Response to Planning Application

Application ref: F/2/20/PL

Description: Change the use of 1/2 the site area to a hard standing storage area (resubmission following F/9/19/PL).

Location: Land Adjacent Station Cottages Ford Road Ford BN18 0BH

Proposed Fence and earth mound elevation

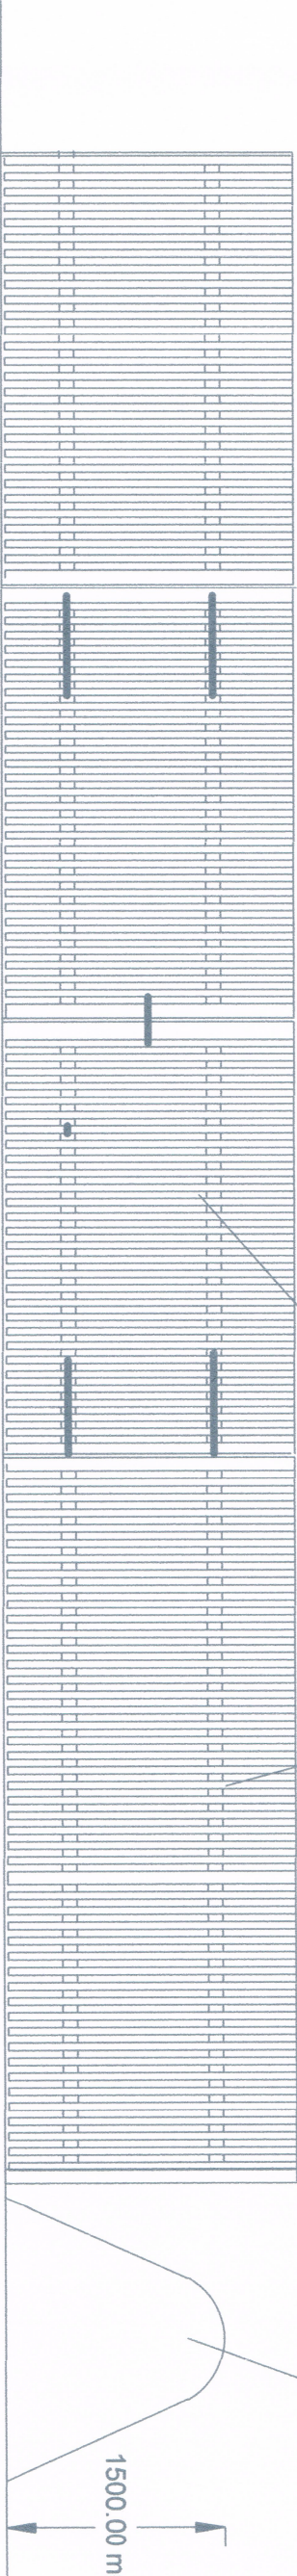
I would require at least to be conditioned with any decision, details of these two areas including the indicated 1.5m bund and the treatment/planting along with the proposals to hide the fence line.

Proposed entrance and hard standing
alteration with change of use

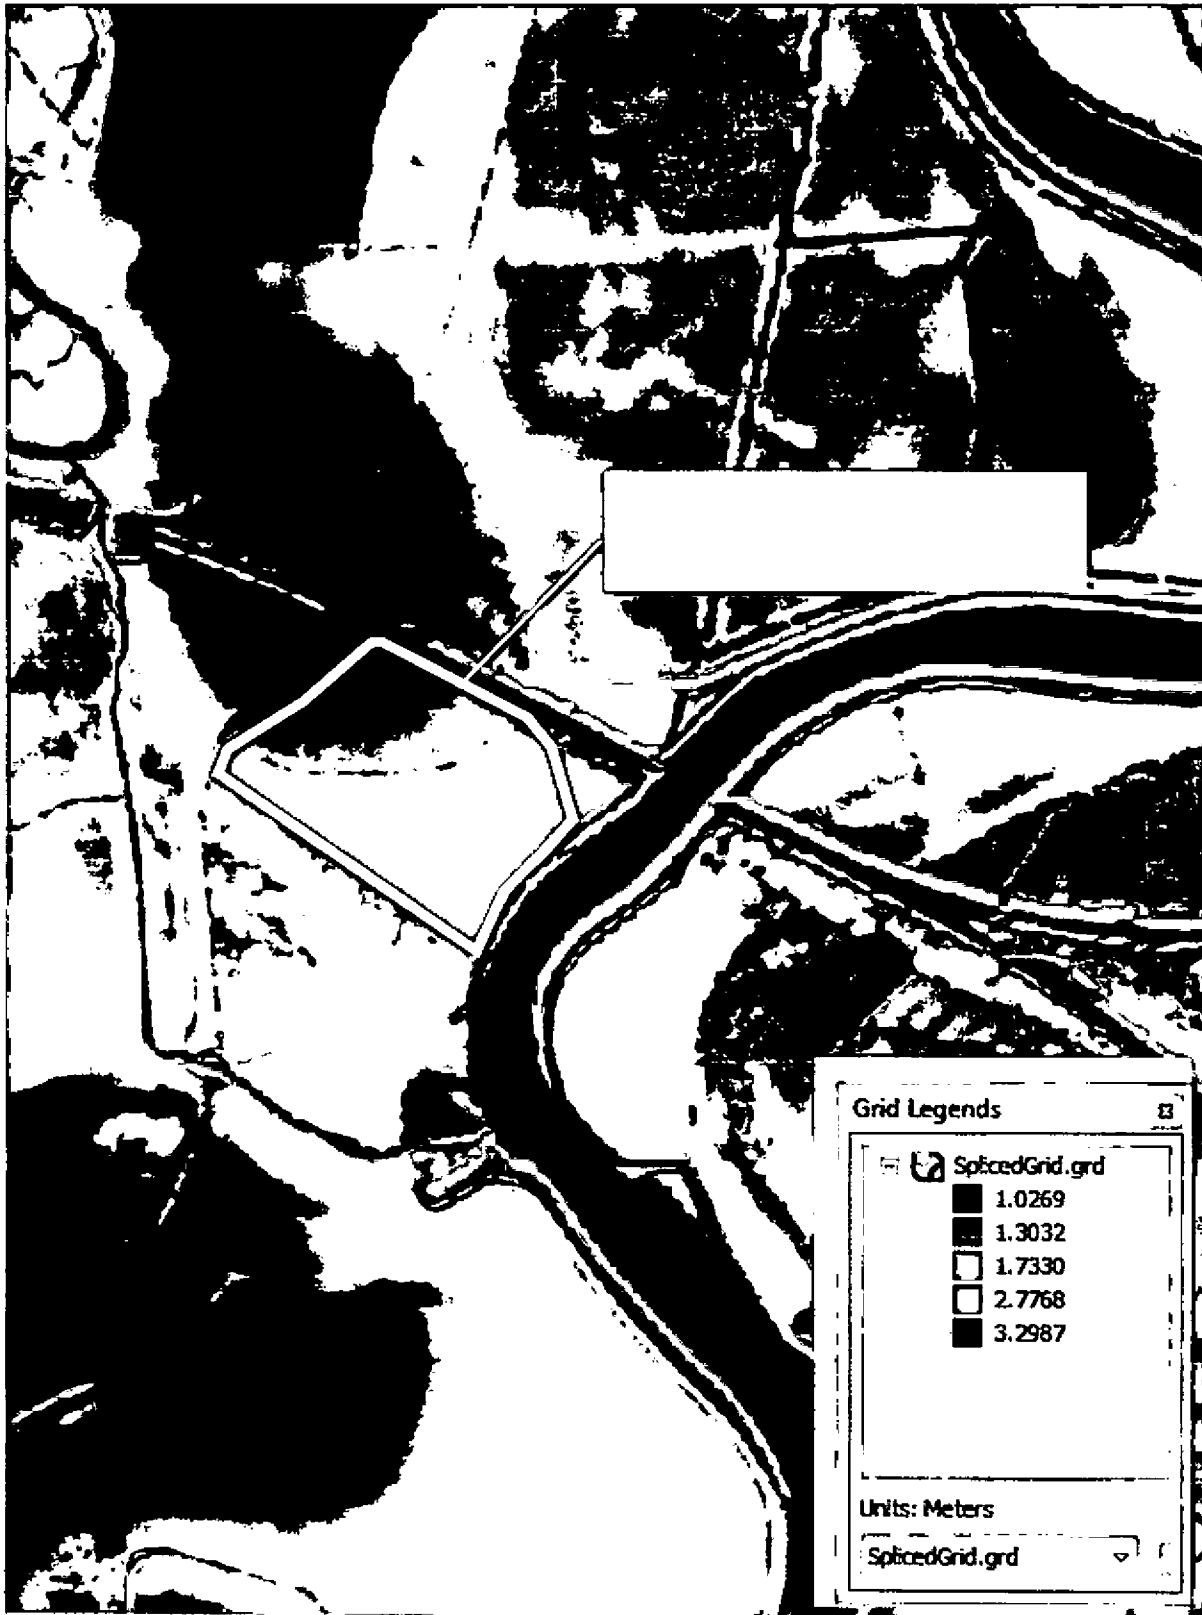
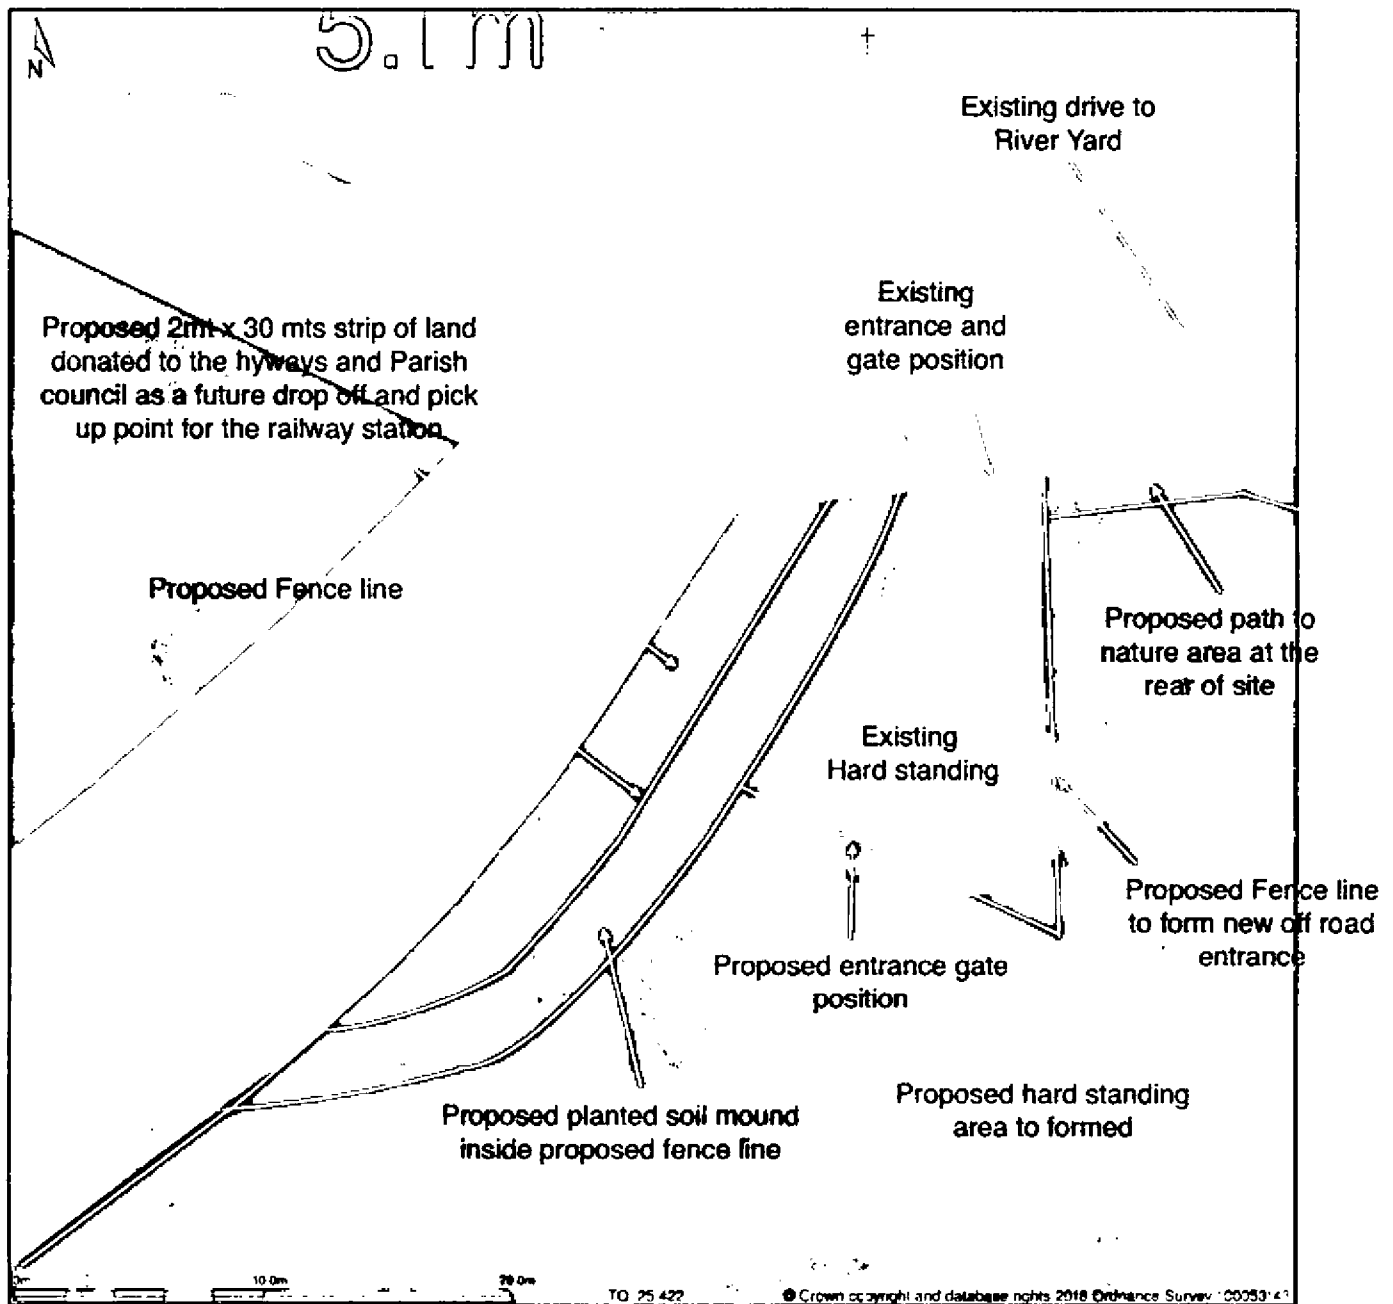
I would be concerned by the loss of greening that this site presently presents and the relationship of 'proposed hardstanding' in relation to the proposed nature area and how these would work together.

I would recommend the submission of landscape details to show the existing trees and shrubs and further to provide mitigation proposals to improve on the scheme presently submitted in relation to the hardstanding and boundary edge treatment.
